Land Use Planning
Yorkshire Water Services Ltd
Midway
Western way
Bradford
BD6 2LZ

Your Ref: 2018/91661
Our Ref: U011627

8th August 2018

Land at Walkey Terrace and Brunswick Street , Heckmondwike - Outline permission for residential development and facilitating engineering operations and full planning permission for access and spine road

Drawing Title: Proposed Site Plan

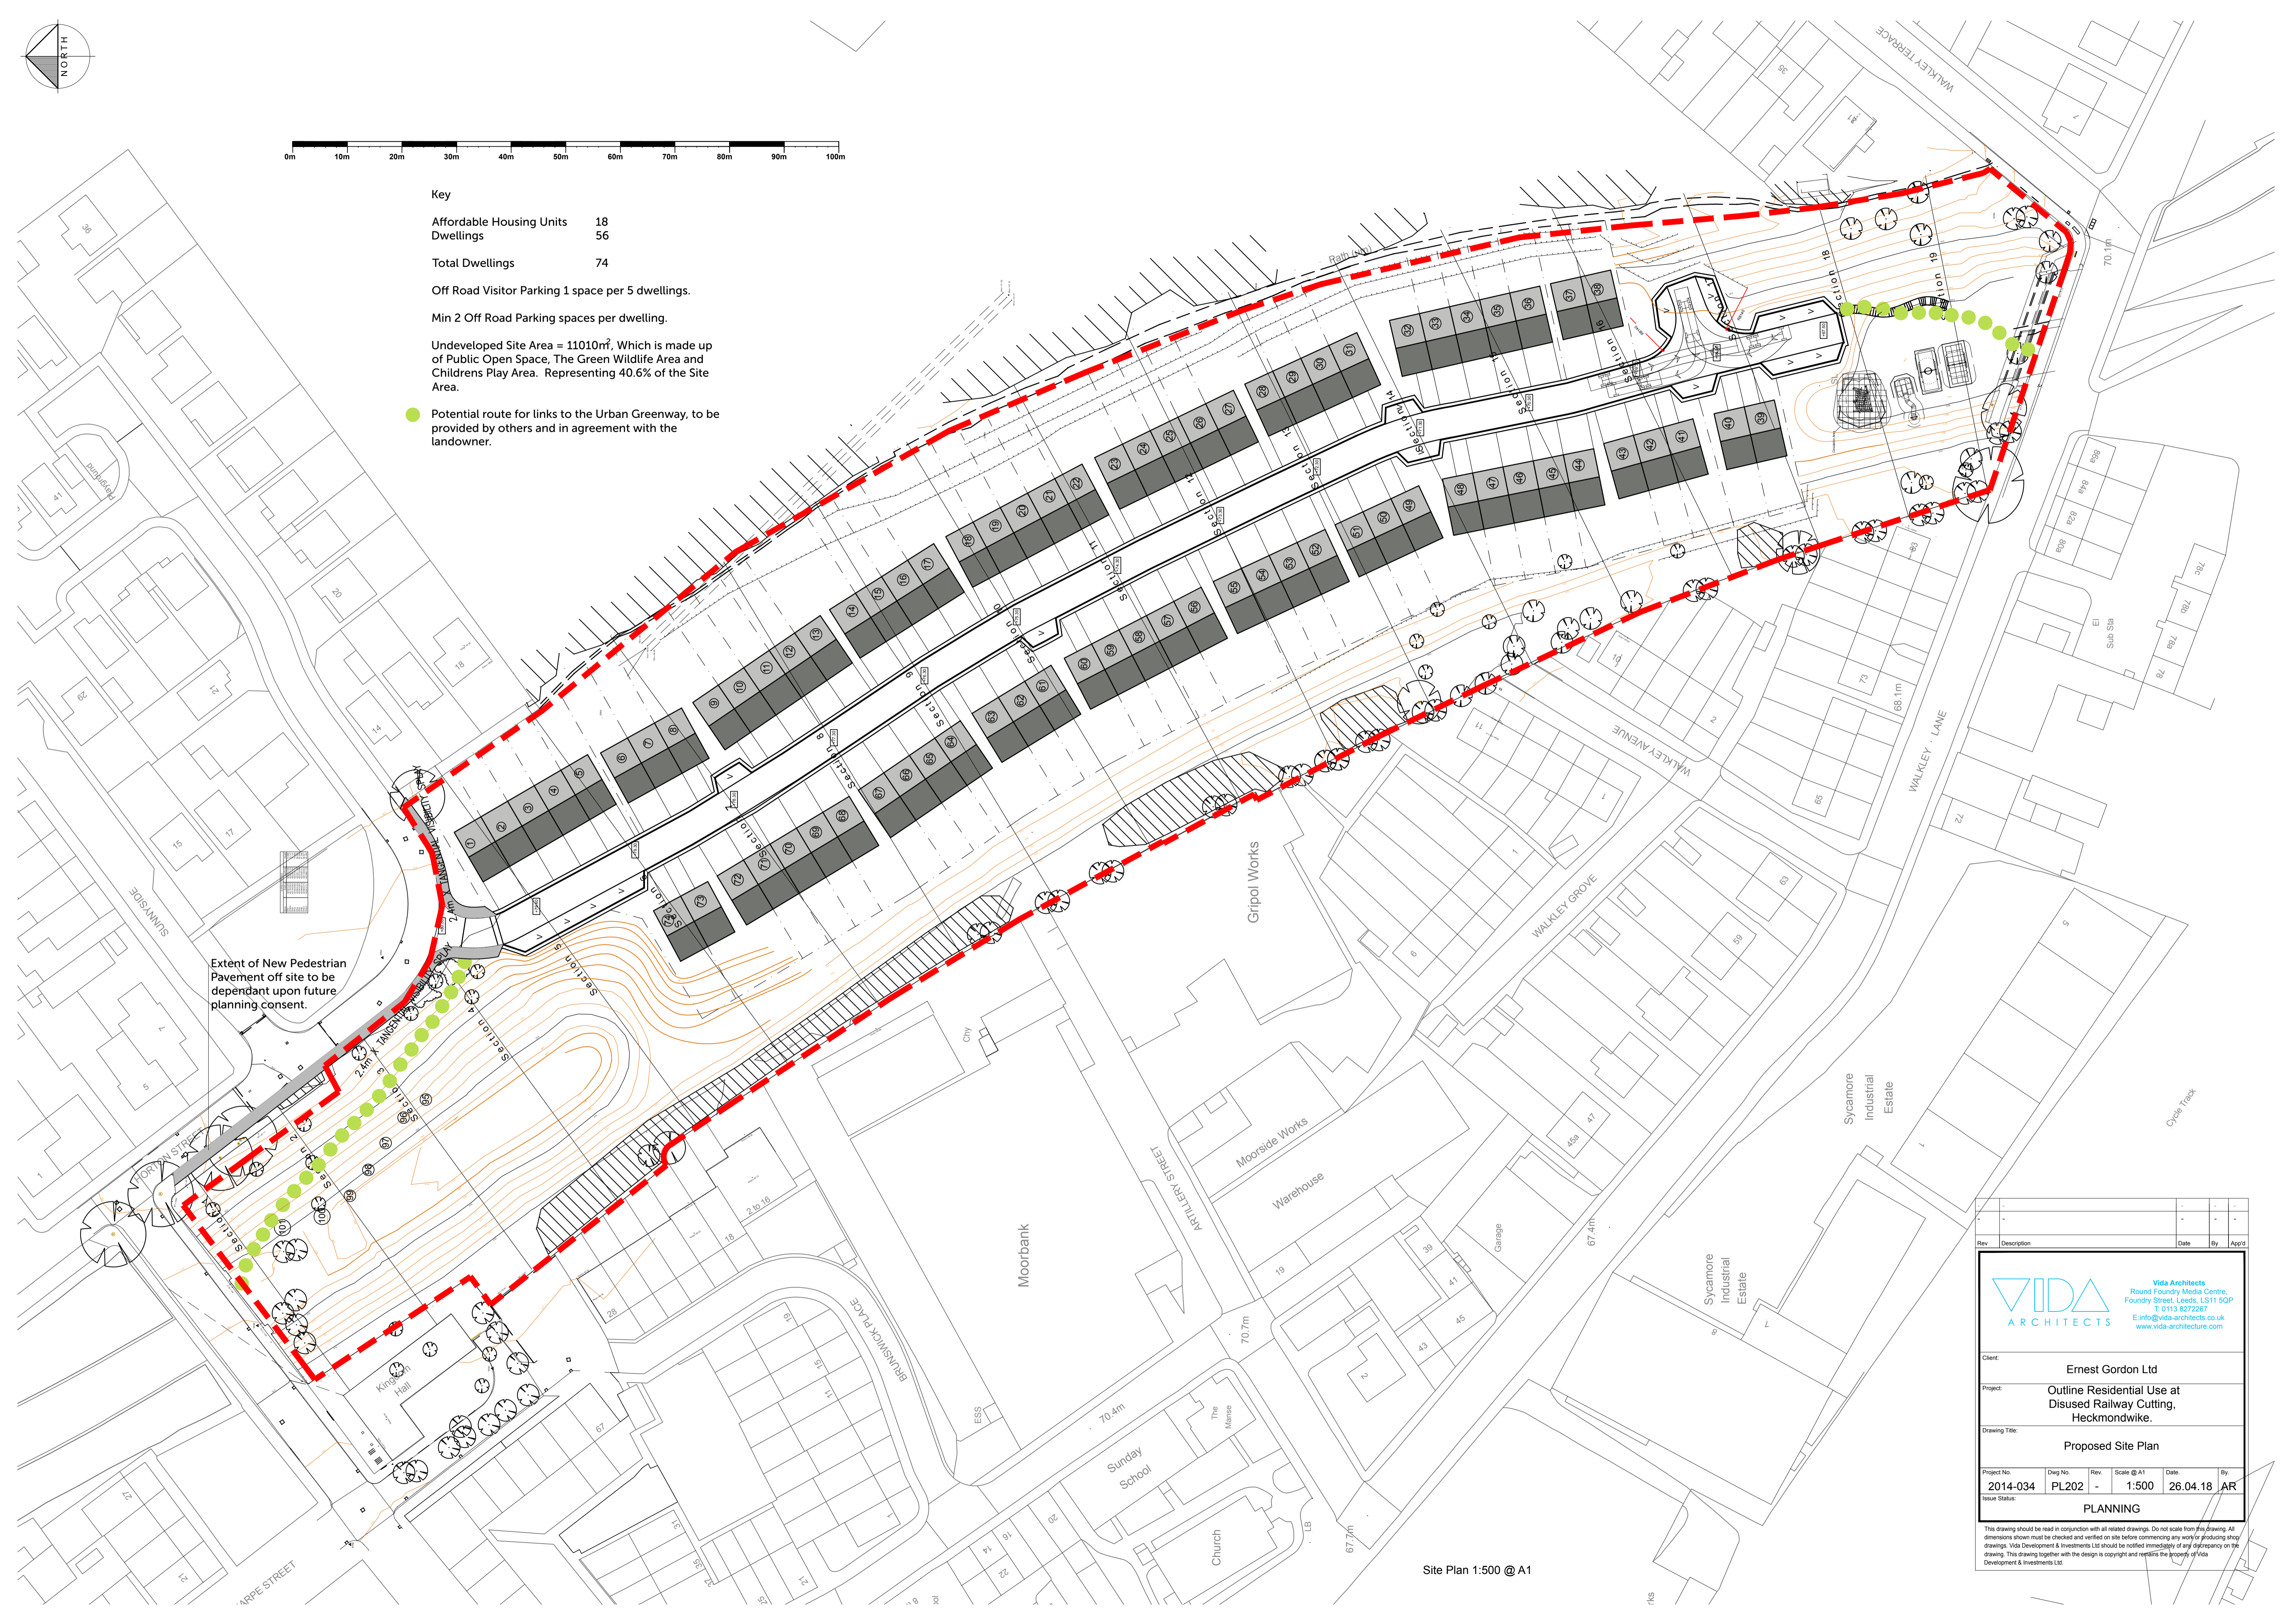
No building or other obstruction including landscape features and alterations to ground levels shall be located over or within 6 metres either side of the centre line of the water main i .e. a protected strip width of 12 metres, that crosses the site . If the required stand -off distance is to be achieved via diversion or closure of the pipe , the developer shall submit evidence to the Local Planning Authority that the diversion or closure has been agreed with the relevant statutory undertaker and that prior to construction in the affected area , the approved works have been undertaken . (In order to allow sufficient access for maintenance and repair work at all times)

An 18" cast iron main lies within redline boundary at the south of the site and it is imperative it is protected during the construction and operational phases of the development. The site layout must reflect the pipe's location and provide adequate protection.
